Your ref: SSD-50725708

Our ref: DOC25/717993

Subject: Dinawan Wind Farm – Response to Submissions

ATTACHMENT A – CPHR comments on Dinawan Wind Farm (SSD-50725708) - Response to Submissions

Figure 12B Threatened fauna species polygon - Plains-wanderer

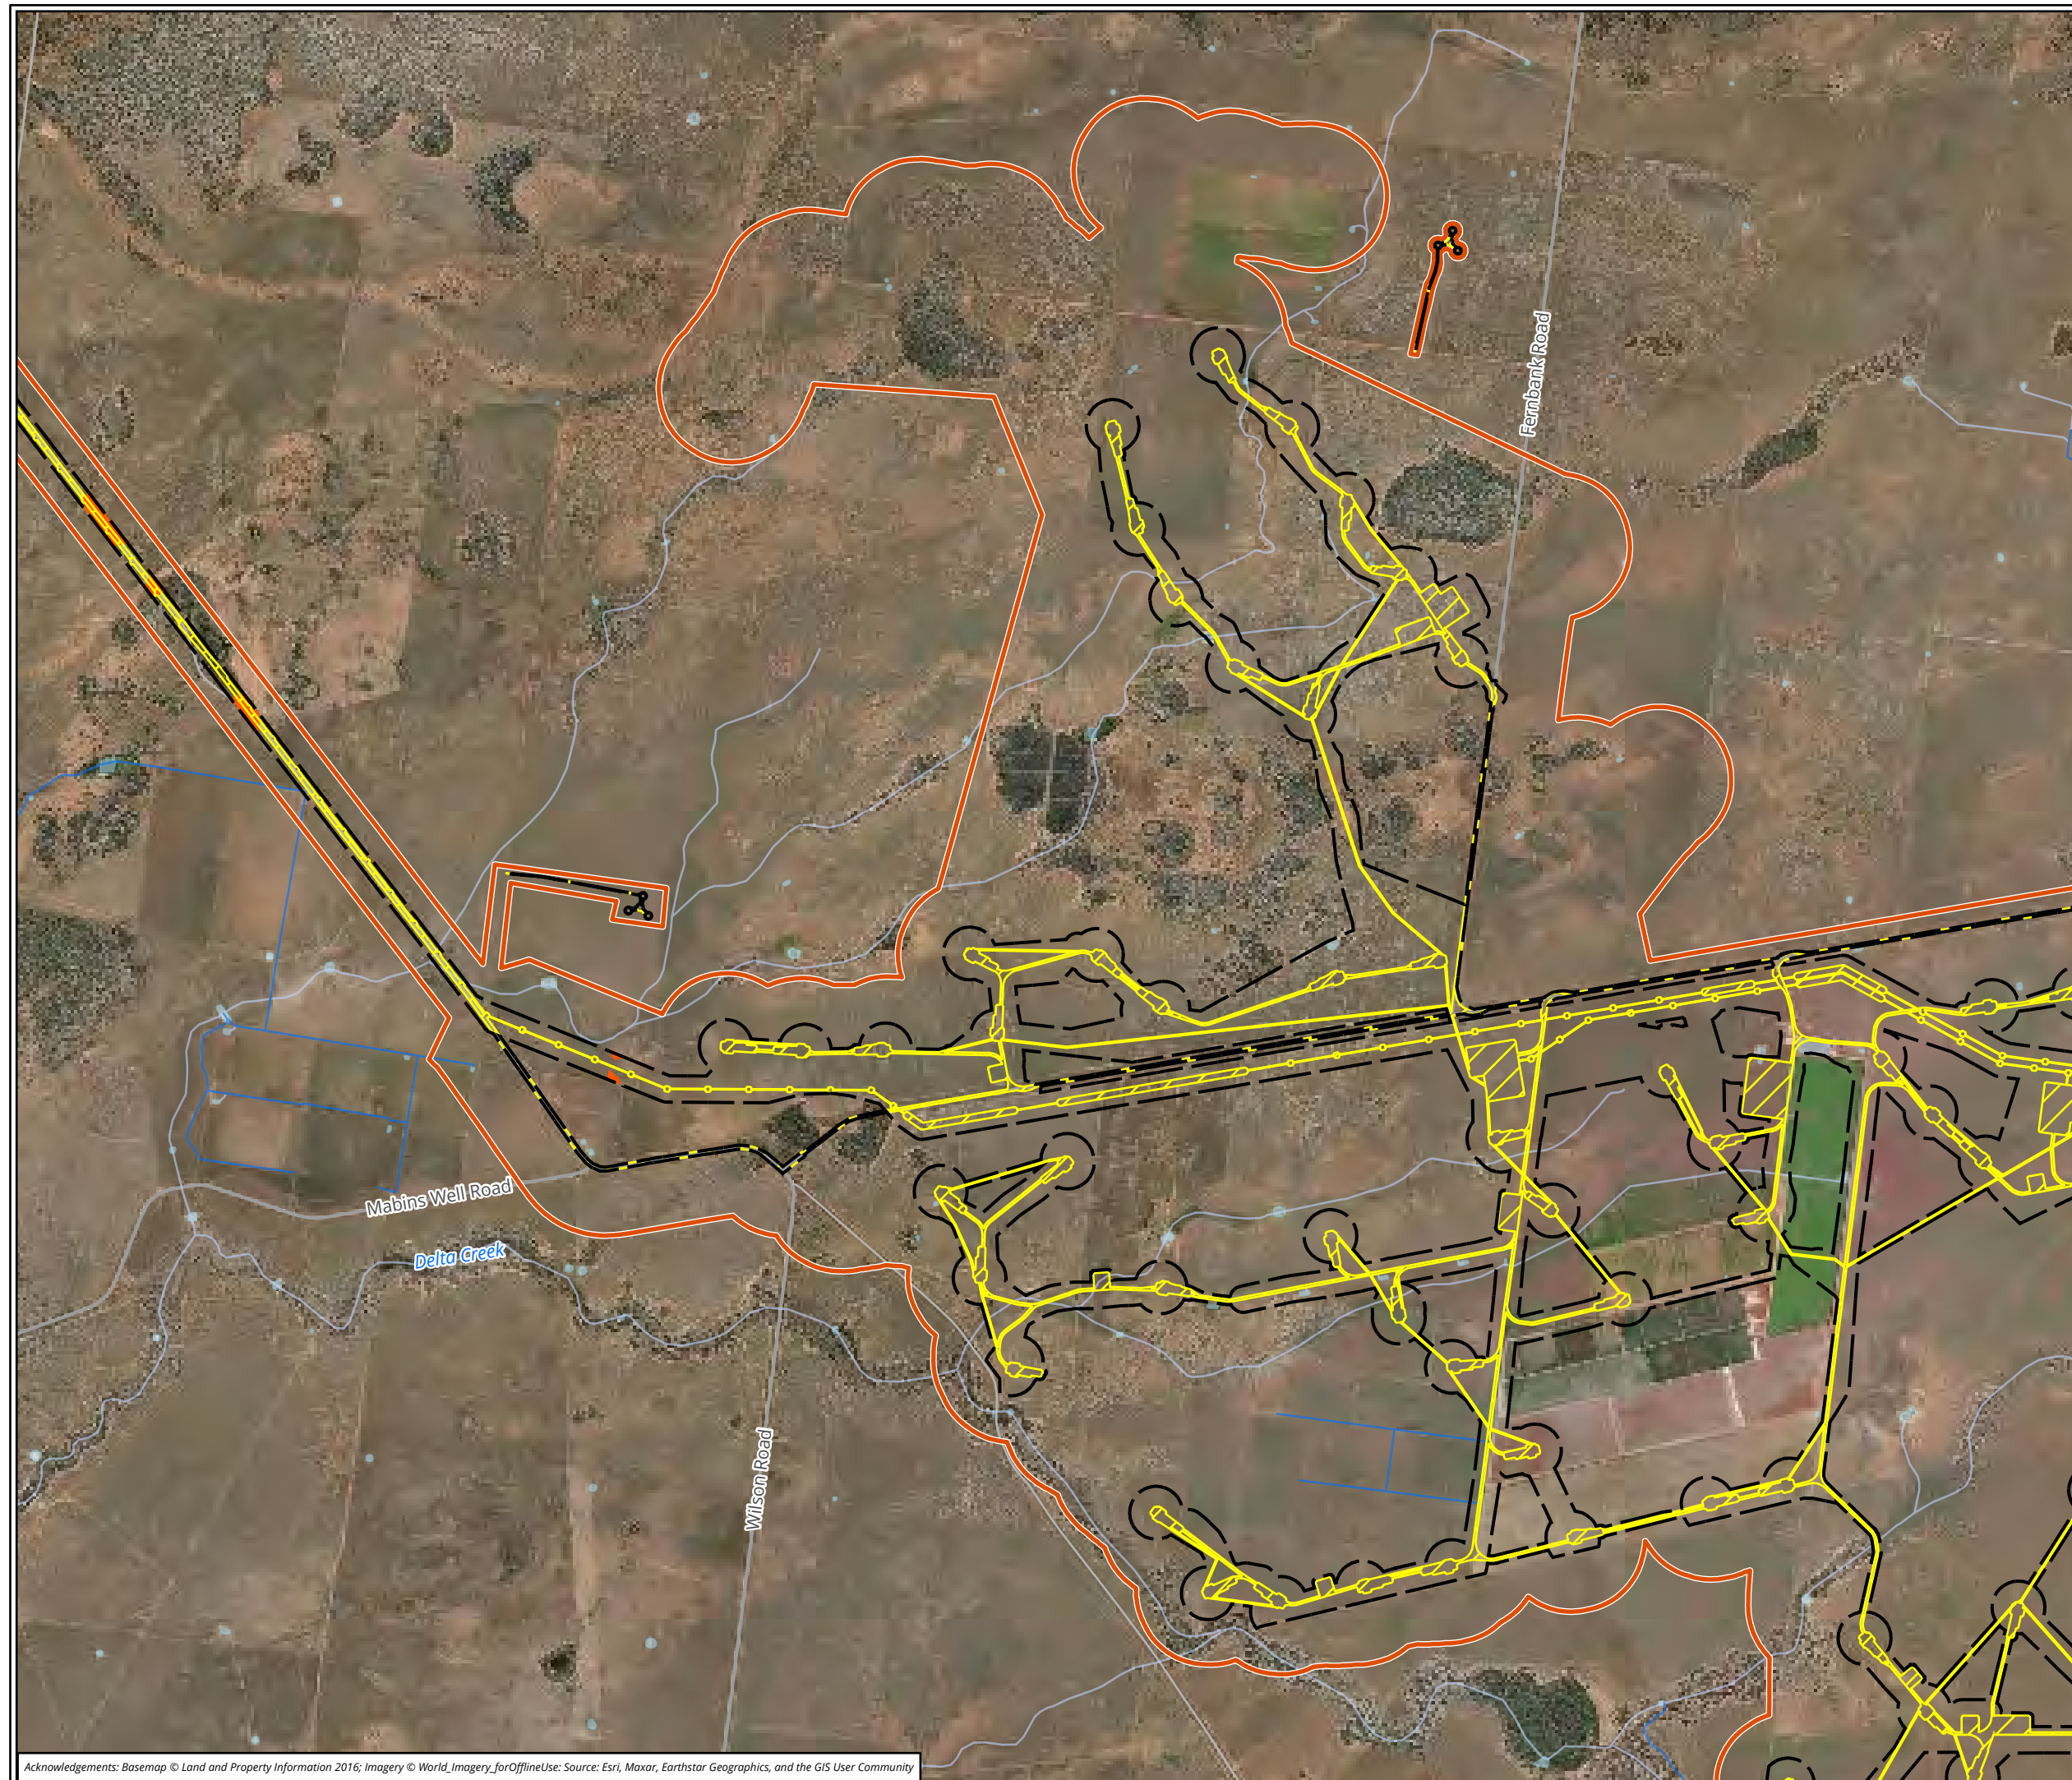
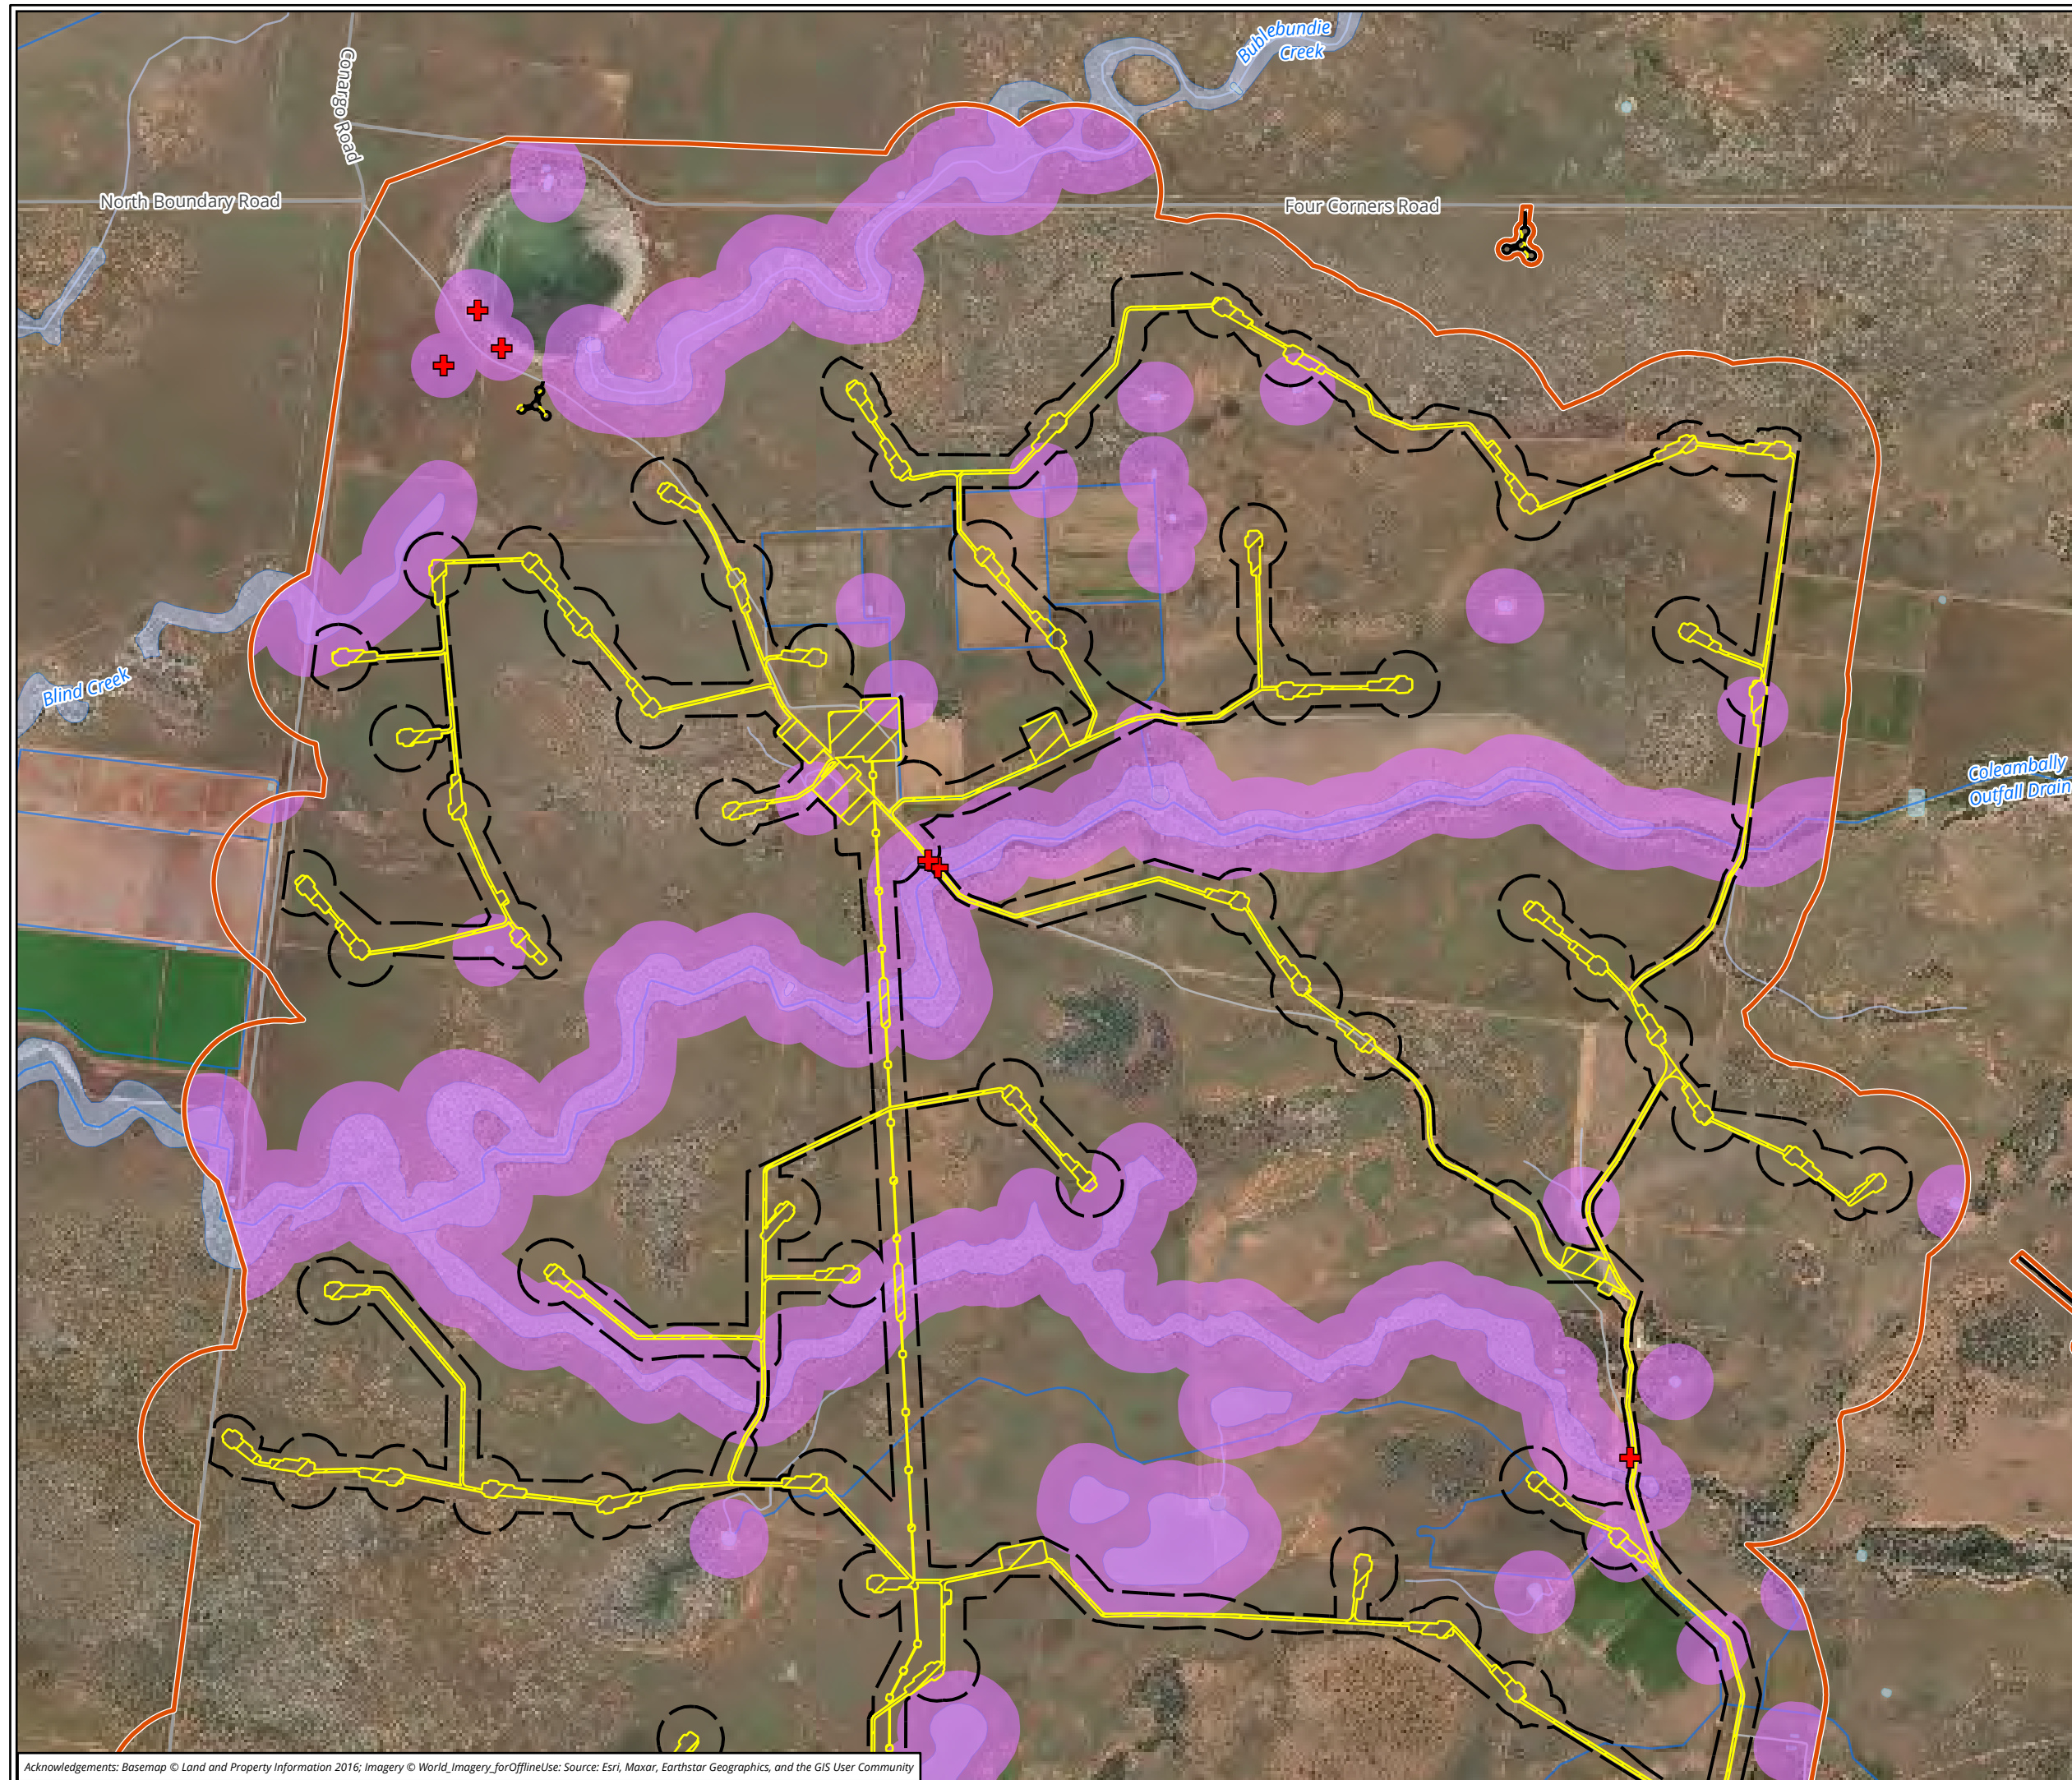
Additional Spring surveys are currently being completed for Claypan Daisy. A revised BDAR, documenting the outcomes of survey is required to enable the decision-maker to determine if there is a SAIL to this species. Also, the SAIL assessment for Plains-wanderer has not considered impacts to all suitable habitats. As per the NSW Bionet Threatened Biodiversity Data Collection (TBDC), all important habitat mapped areas, areas of associated Plant Community Types (PCTs), and suitable habitat identified through additional surveys should form part of the assessment of a SAIL.
Recommend	• Update the BDAR with the SAIL assessment for Claypan Daisy following completion of the Spring 2025 surveys. • As per the TBDC, update the SAIL assessment for Plains-wanderer at Appendix 5.1 to include all impacts to associated PCTs as impacts to the species.
